EL PASO COUNTY PLANNING & COMMUNITY DEVELOPMENT SIGN APPLICATION

Name: John Chapman
Address: 18065 Saddlewood Rd Monument CO 80132

Zone: RR-5
Legal Description: That part of N2 of Sec 17E of Canterbury West, N of Saddlewood Rd + W of Canterbury E section 16-11-66

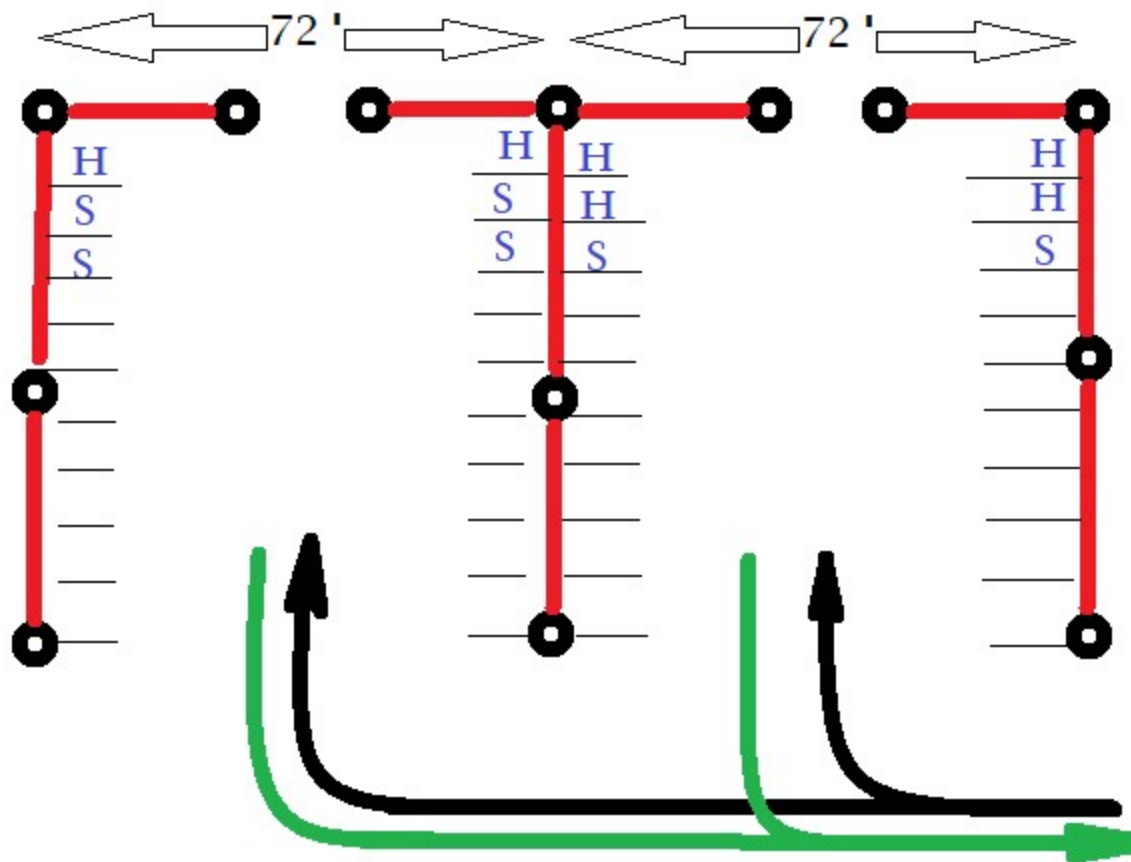
Please provide the distance of the proposed sign from the public roadway. The proposed sign cannot adversely affect the sight distance of the intersection.
